Glyn Rhonwy Pumped Storage Development Consent Order

Deadline 2 – Table of DCO amendments

PINS Reference	EN010072	
Document No.	SPH_GREX_DCOD2_01	
Authors	BS	
Revision	Date	Description
0	13 April 2016	Issued for Deadline 2

**J | TYPICAL TUNNEL SECTION**

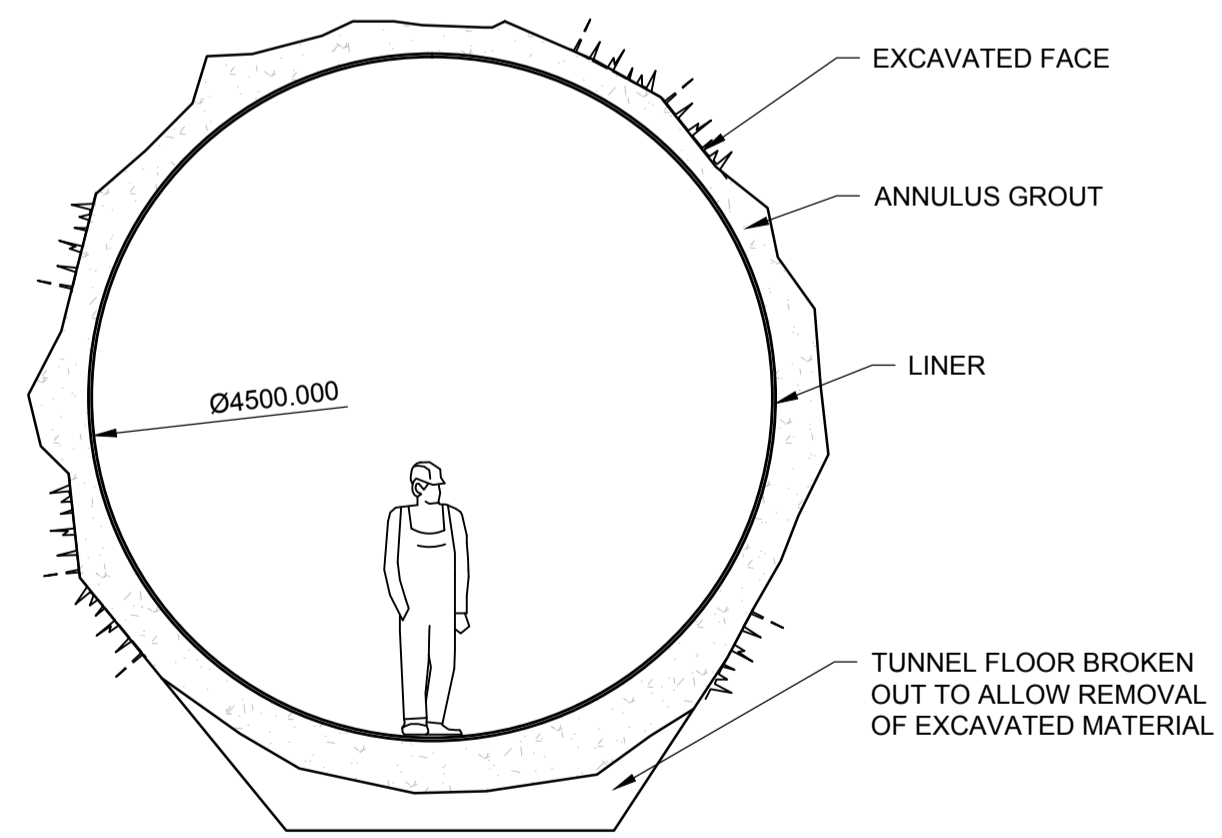
4. The Applicant's Changes			
	Article/ Requirement	Reason for change	Change
4.1	Article 6(1)(b) Power to deviate	To better define the vertical limits of deviation	<p>The Applicant has amended the requirement as follows:</p> <p>(a) in relation to the underground structures, vertically upwards or downwards to any extent which may be necessary or expedient from the ordnance datum levels shown in the indicative engineering drawings and sections, <u>and vertically downwards to a maximum of 10m from the ordnance datum levels shown in the indicative engineering drawings and sections.</u></p>
4.2	Requirement 5 Detailed design	To include a new parameter on work 2, the penstock	<p>The Applicant added into the parameters table for Work 2 as follows:</p> <p><u>4.5m</u> <u>(Maximum internal diameter)</u></p>
